**RE:    *PPR-19-006 Palmer-Williams Solar Facility First Submittal***

Thank you for the comments dated March 4, 2019 for the above-mentioned project. In an effort to address your comments concisely and simplify your review process, we have summarized your comments and our responses below.

| DWG. NAME<br>096495003_EC_CV  |              |                         |

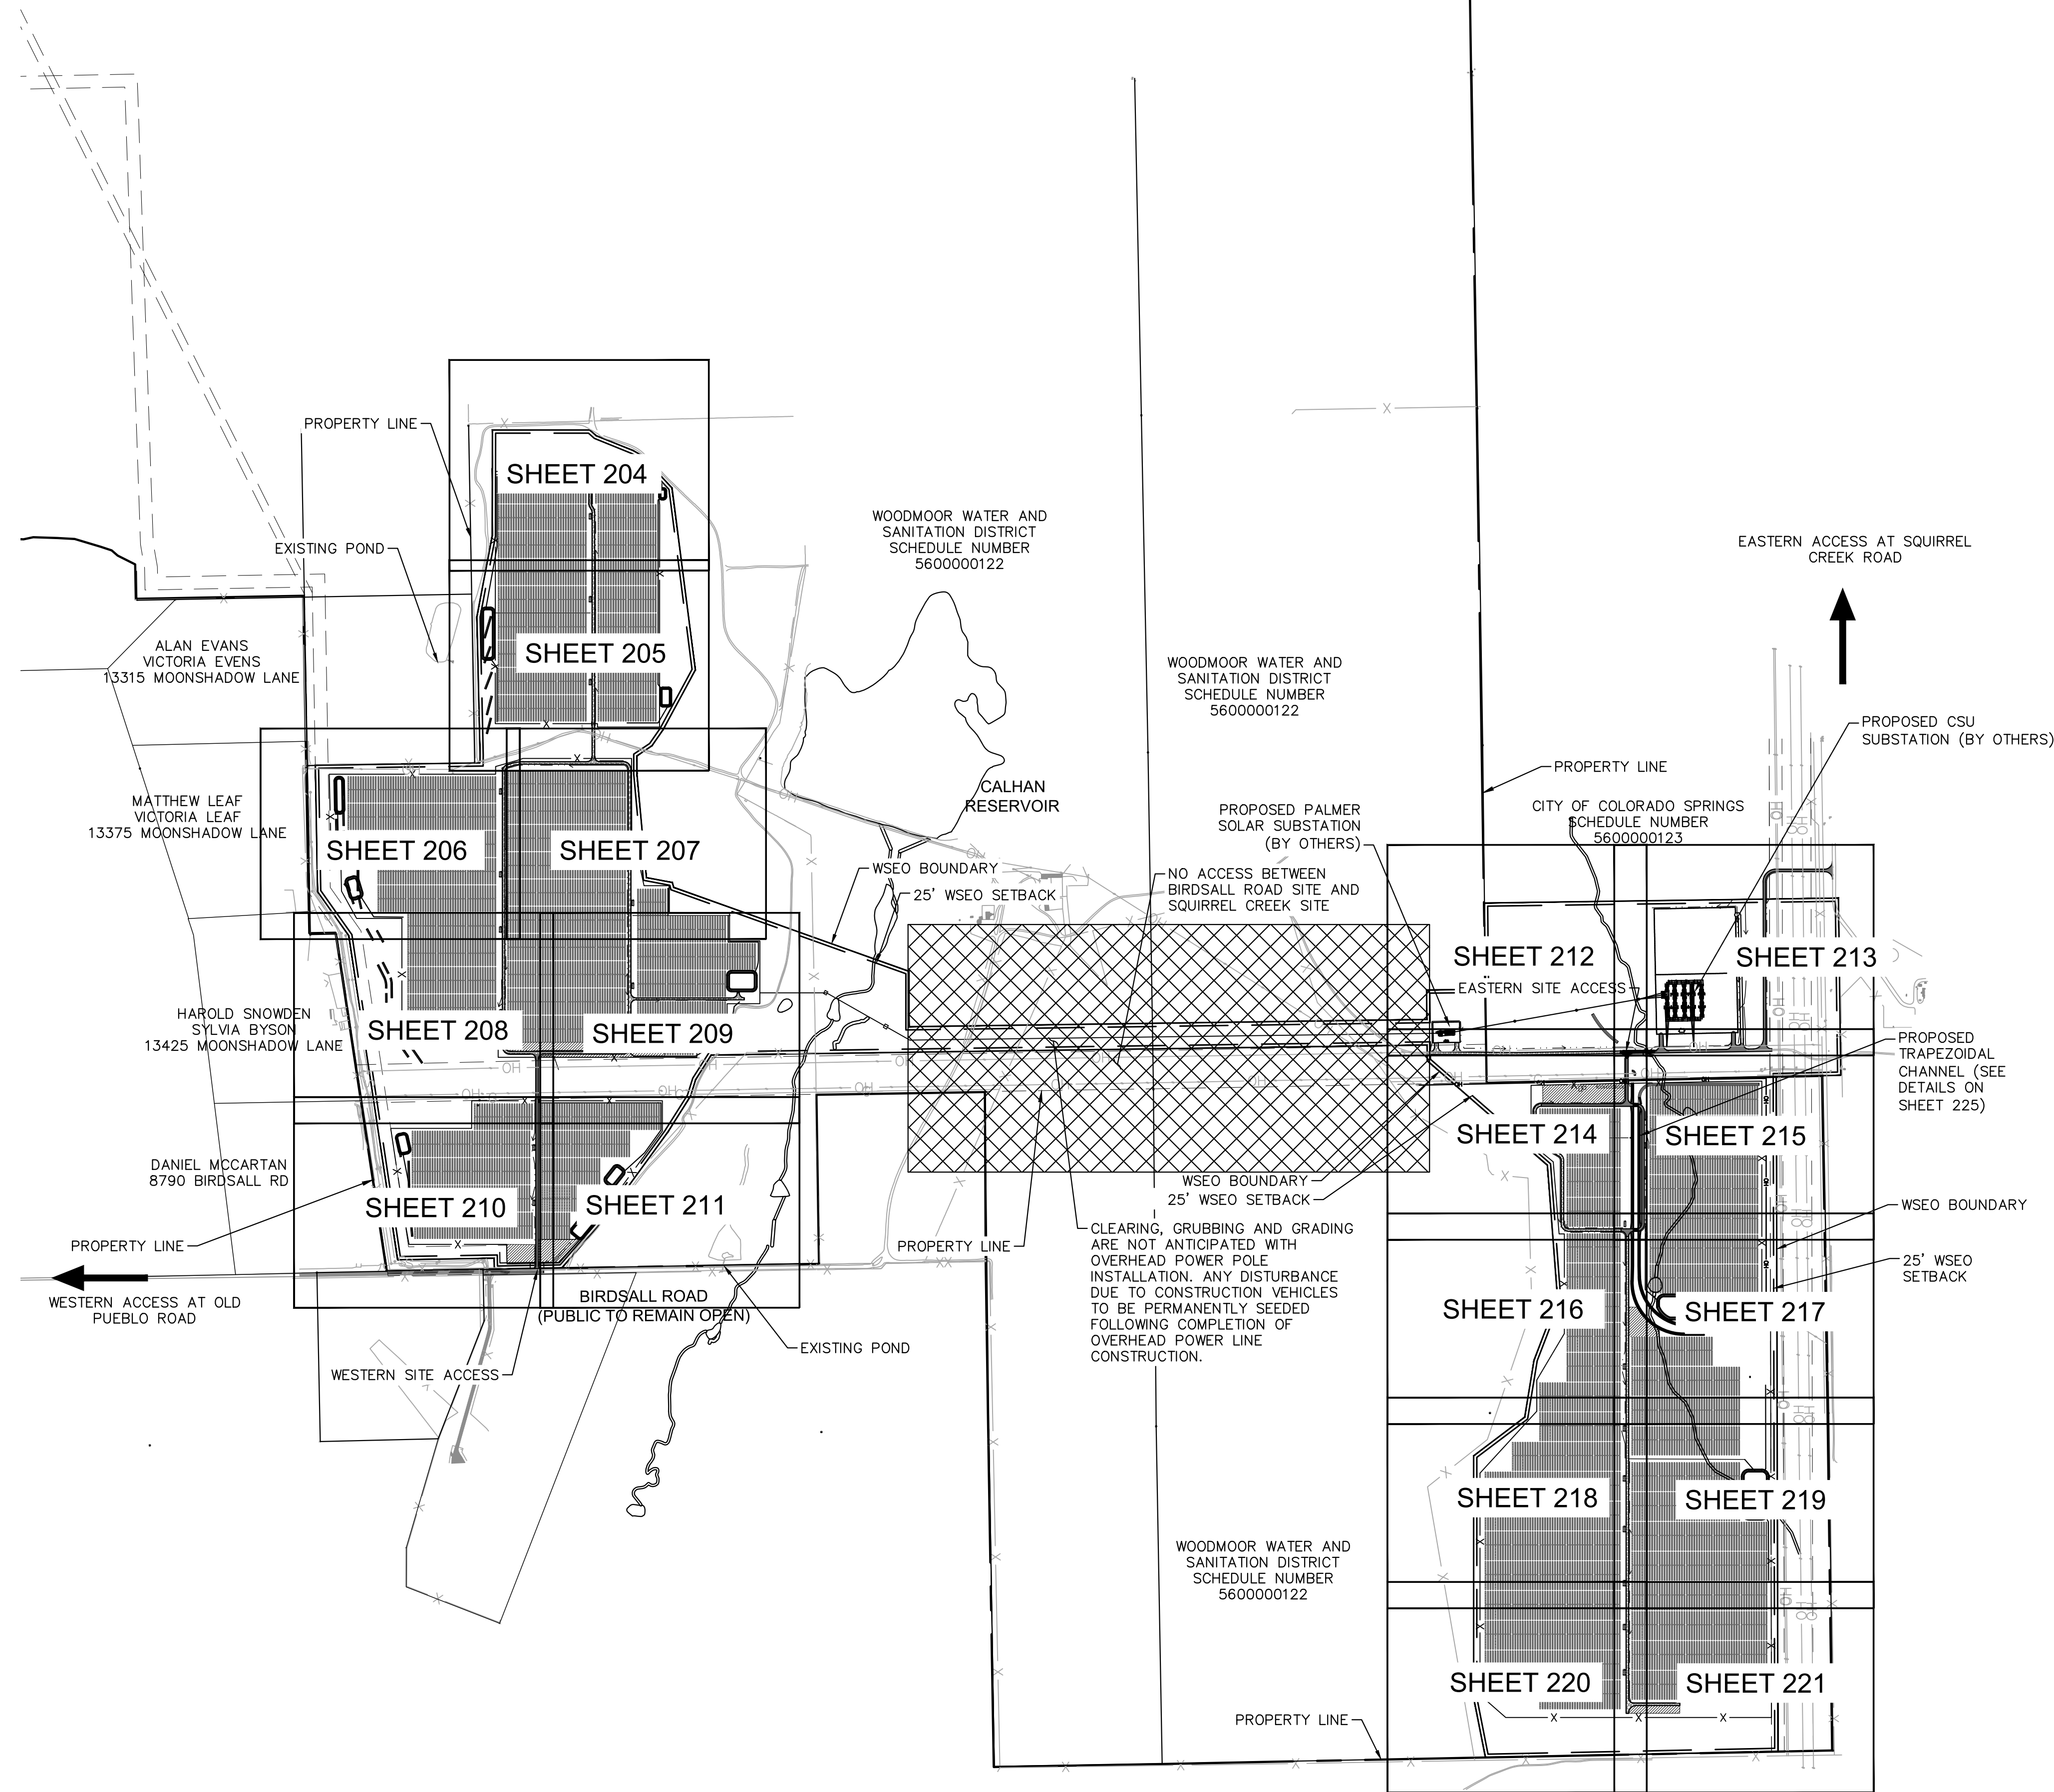
1. Change “DSD” to “PCD” in note no. 5.  
*Response: This has been revised.*
2. Update El Paso County Engineering contact information to “2880 International Circle 80910”  
*Response: This has been revised.*
3. Add “PPR-19-006” to bottom right hand corner of plans.  
*Response: This has been added to all sheets.*

205

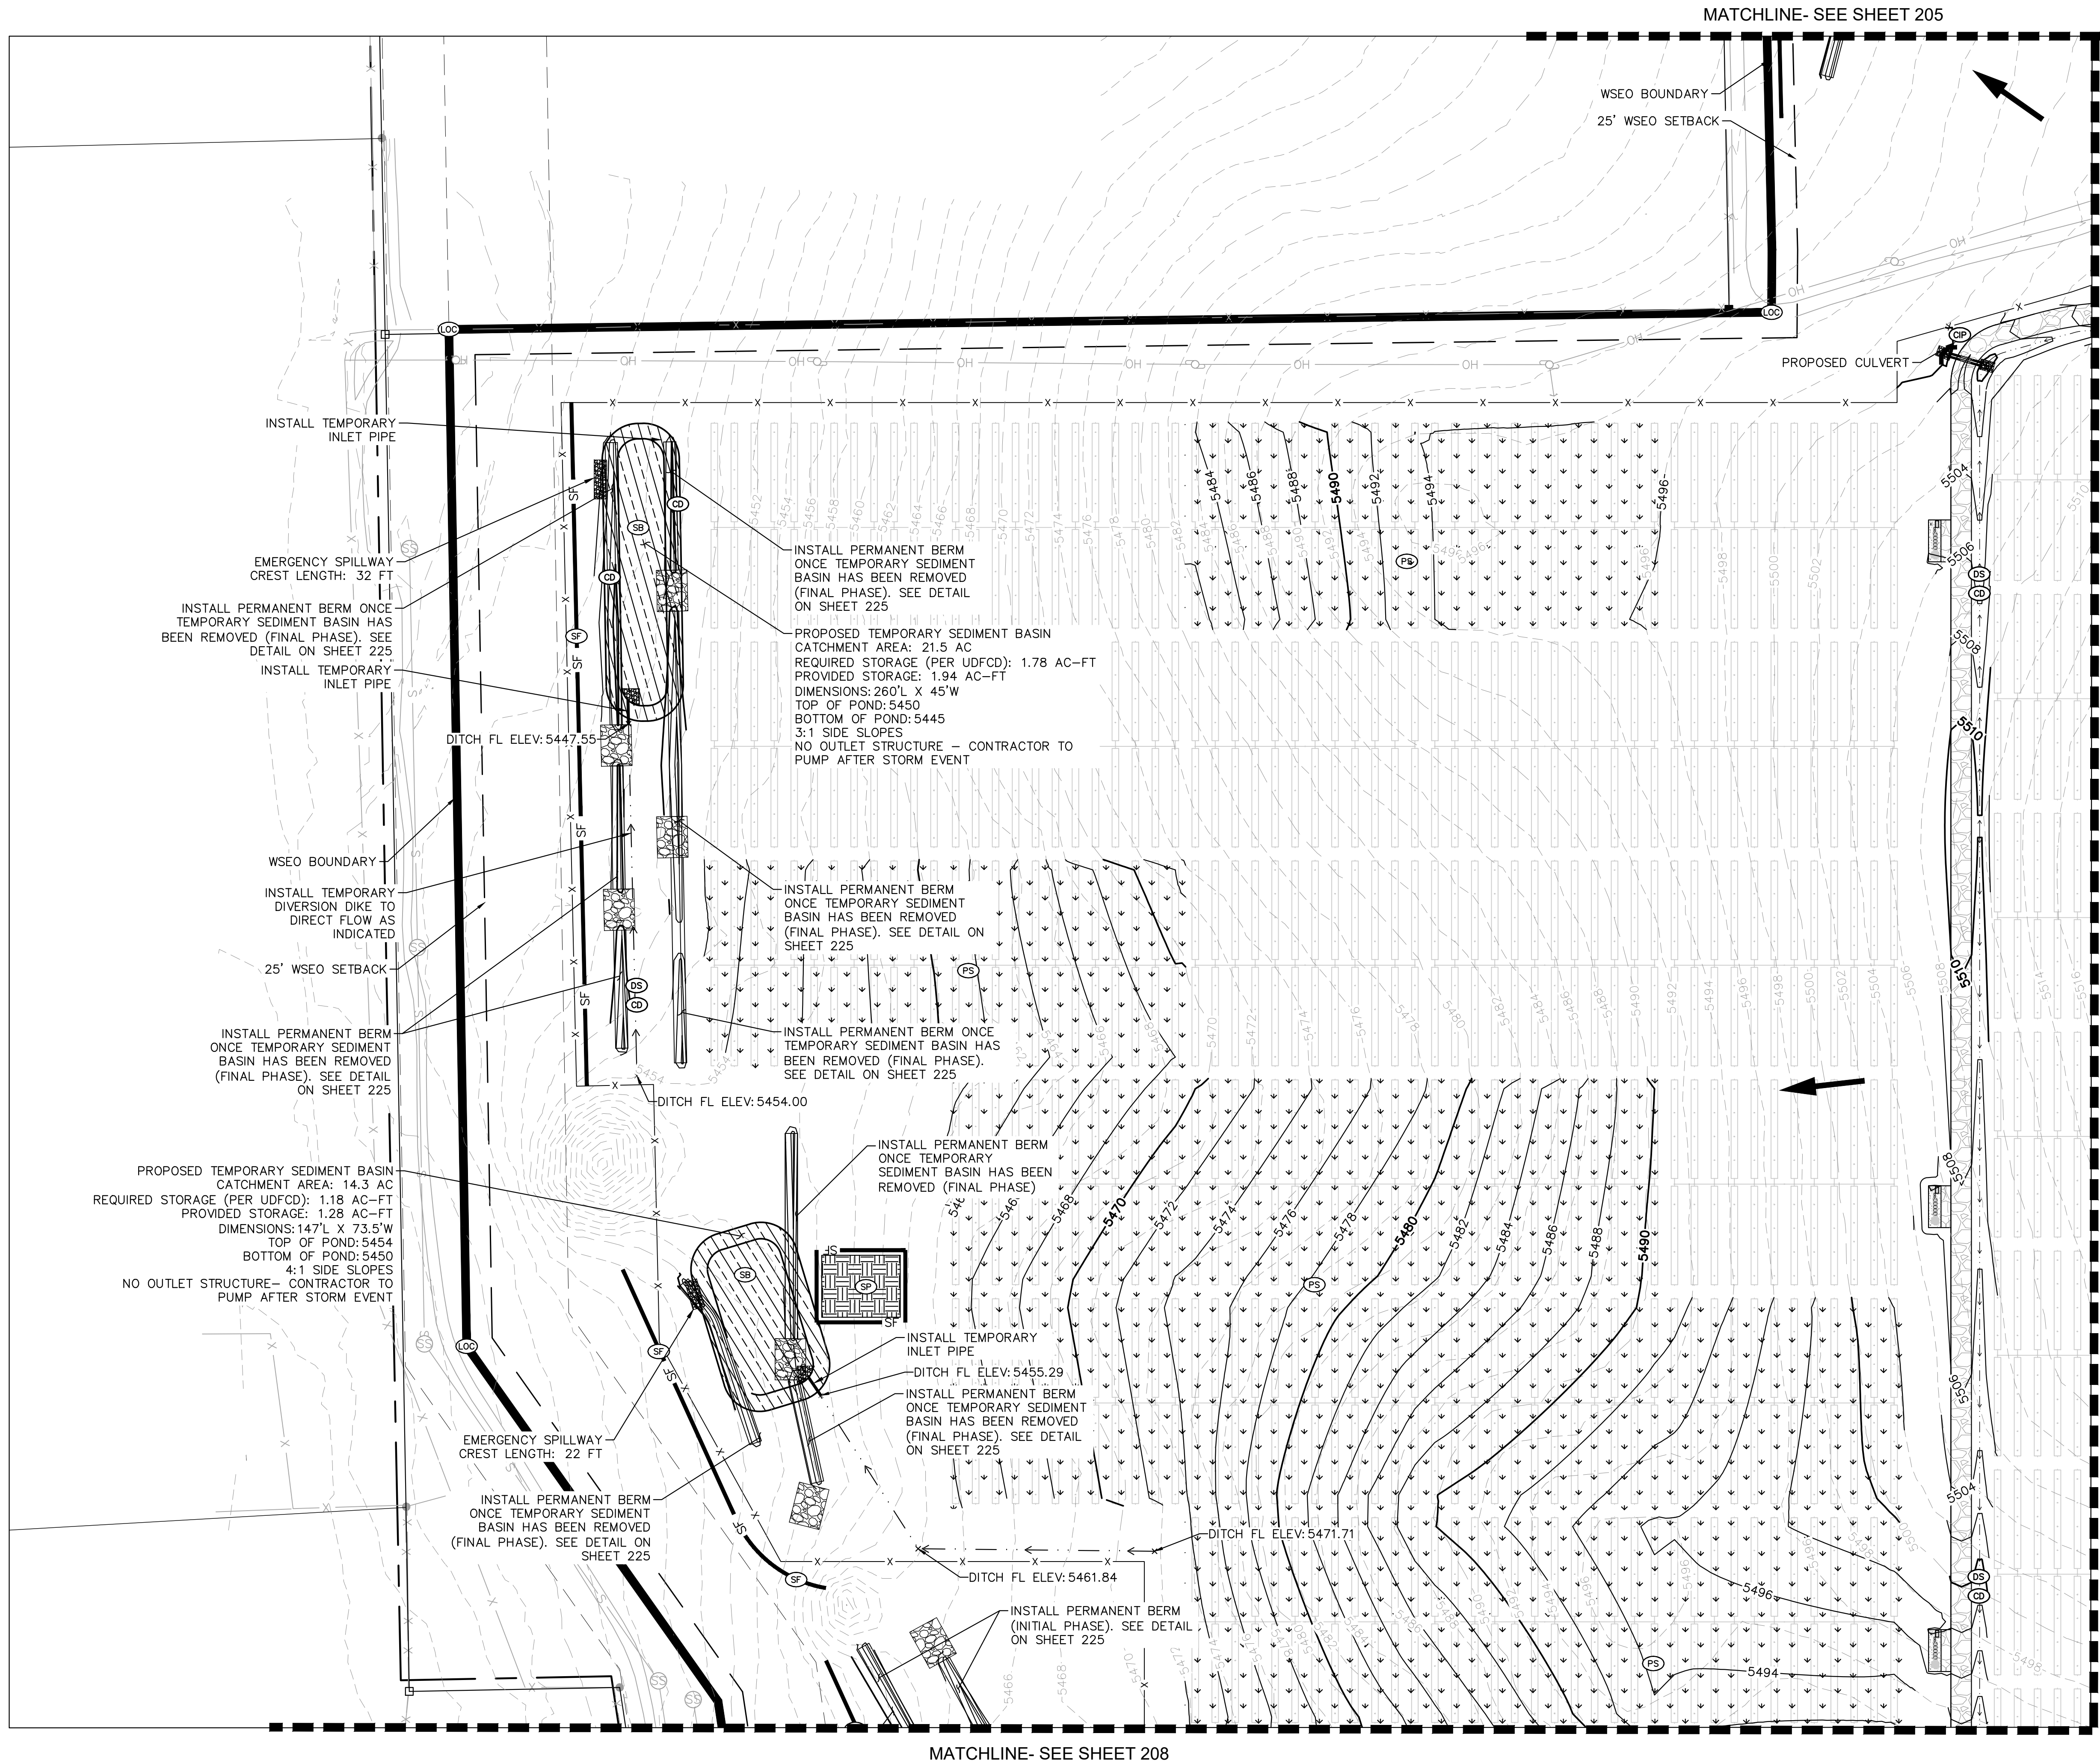
5. If the sediment basins do not have an outlet, a deviation request needs to be approved. If a deviation is requested, it should include the requirement that the sediment basins would be emptied within 40 hours after the rainfall (note #3 on Figure SB-1 and UDFCD page SB-5).  
*Response: PVC riser pipes with outfalls have been added to all temporary sediment basins that were previously “non-draining”. Therefore, a deviation request is not being pursued as the temporary sediment basins now comply with the Criteria.*

| DATE:<br>FEBRUARY 22, 2019 | PROJECT NO.<br>096495003 | SHEET NO.<br>219 |

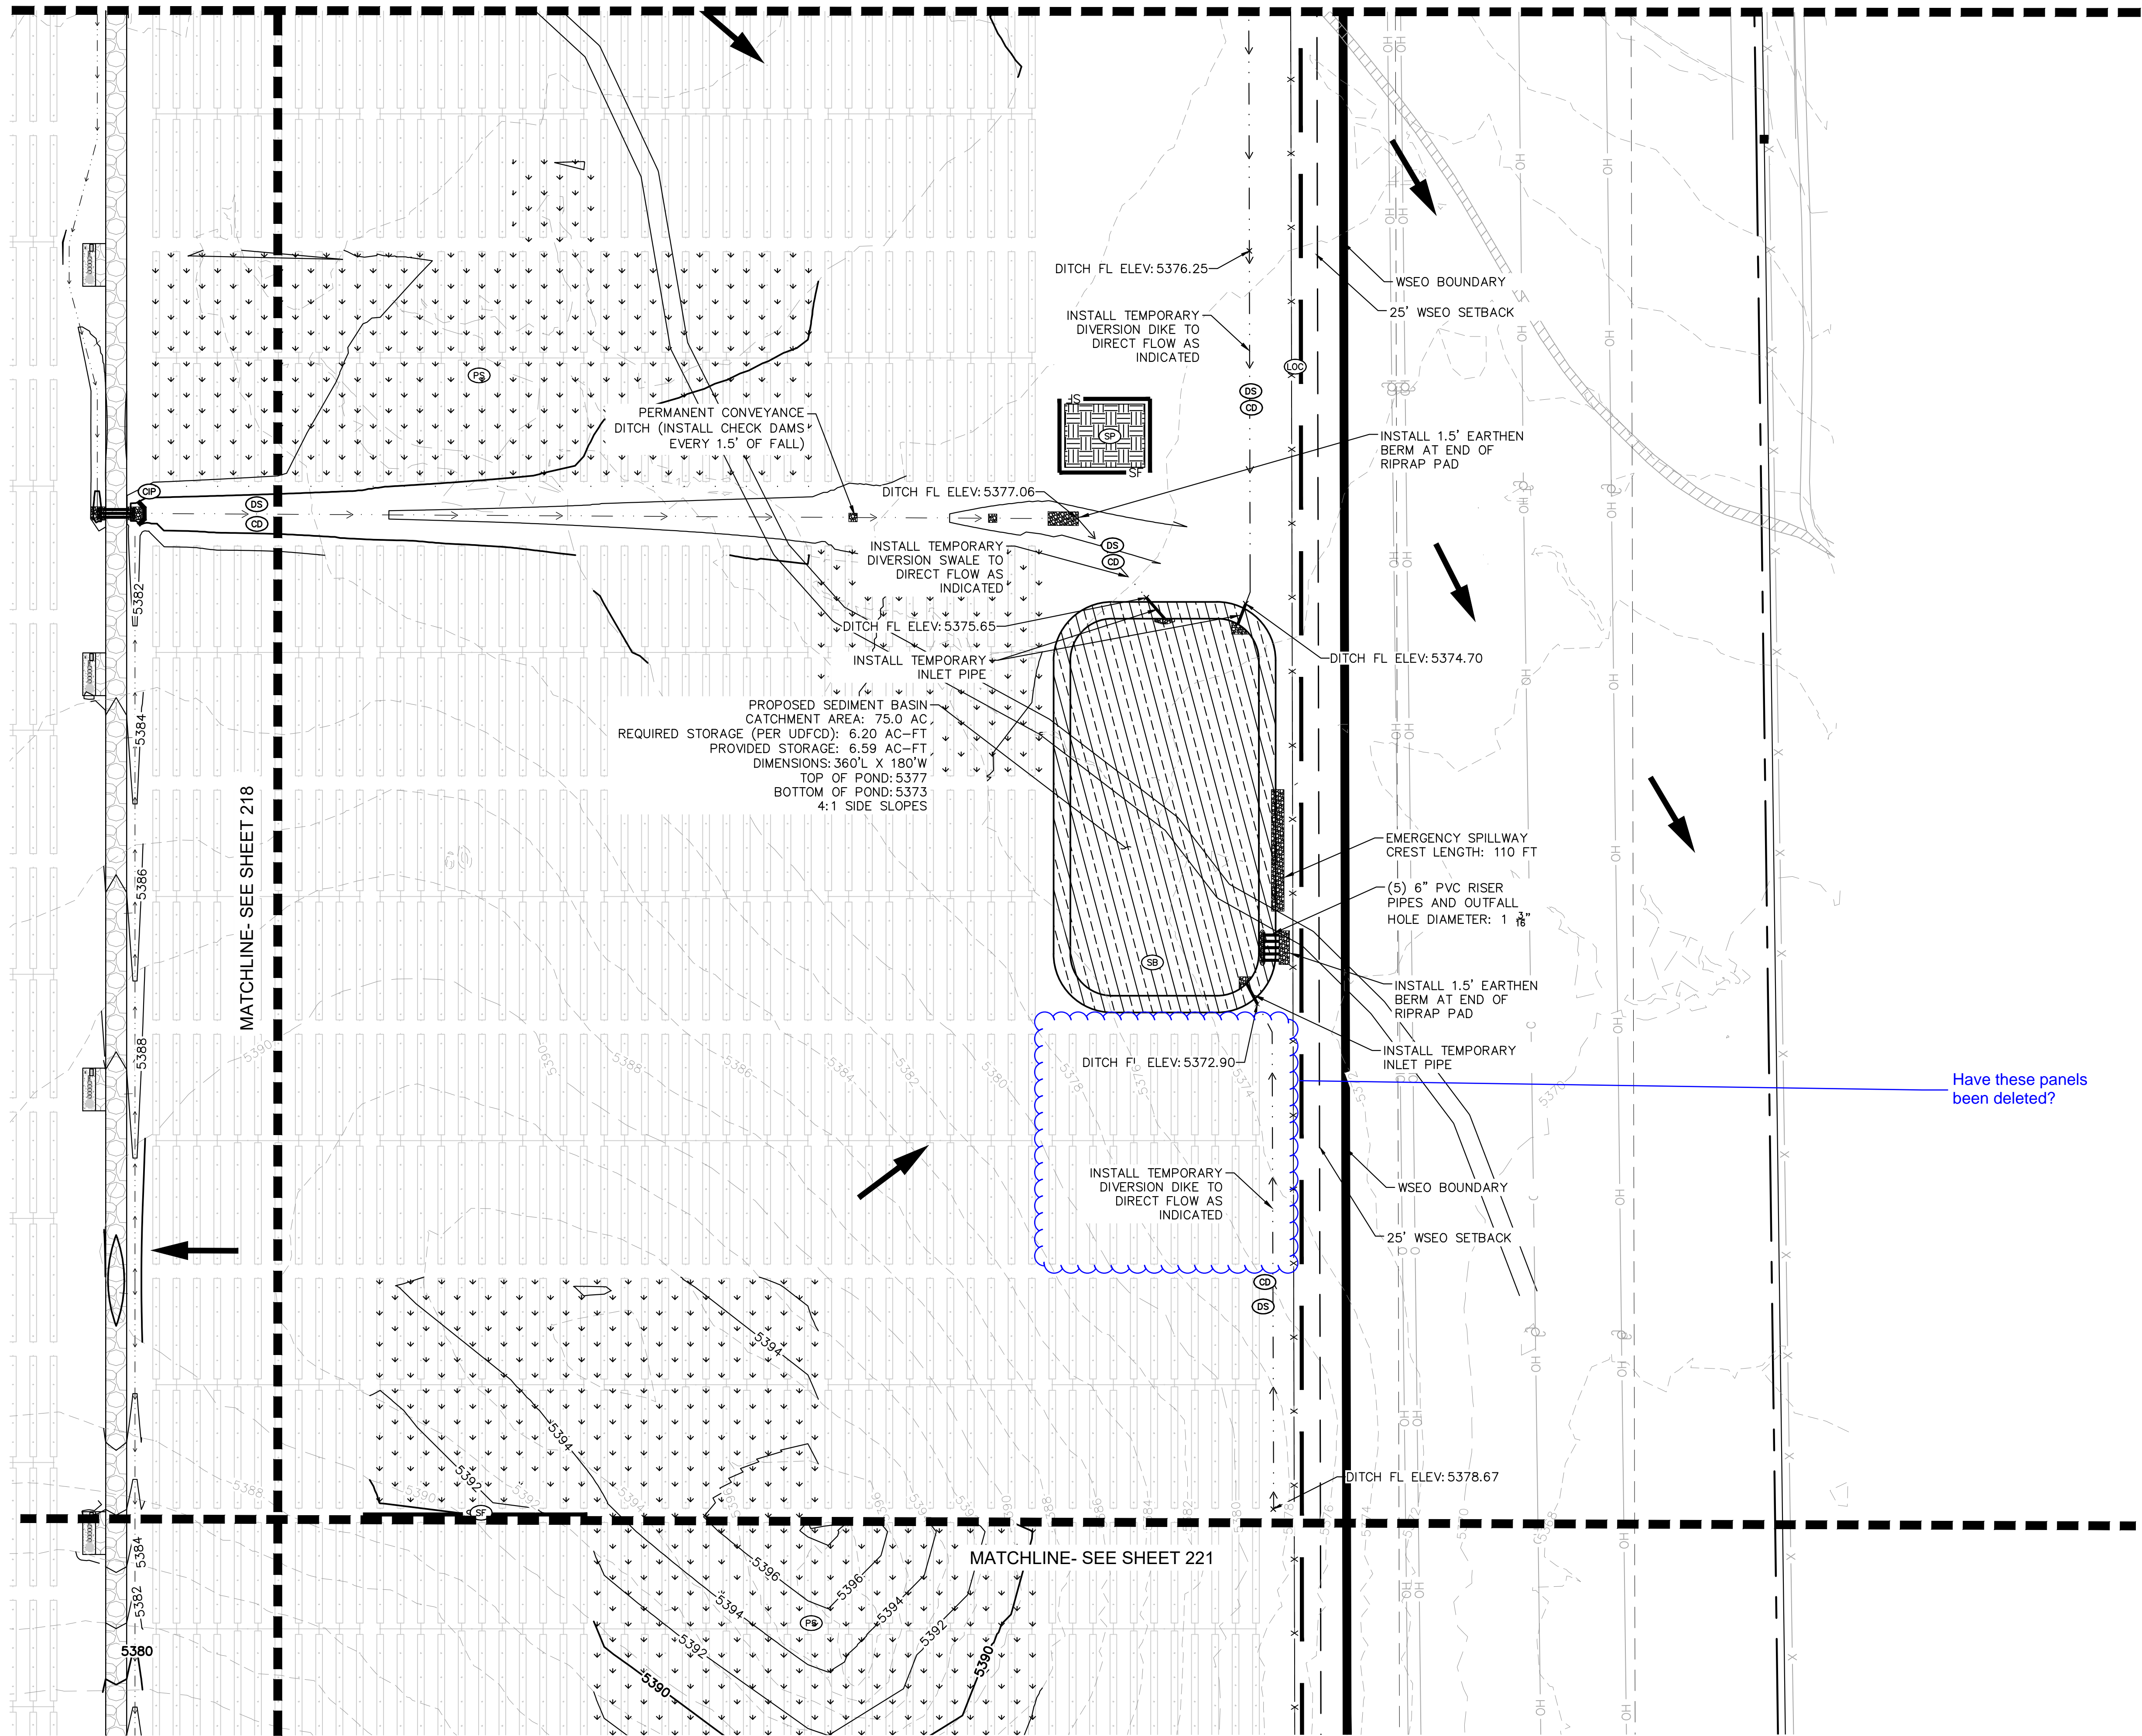
1. Have these panels been deleted?

*Response: The location and shape of the panel array on the Squirrel Creek Site were optimized for construction of civil features and to fit the shape of the WSEO boundary. Reconfiguration reduced the number of rows on the Squirrel Creek site by 150. Configuration complies with zoning and 1041.*
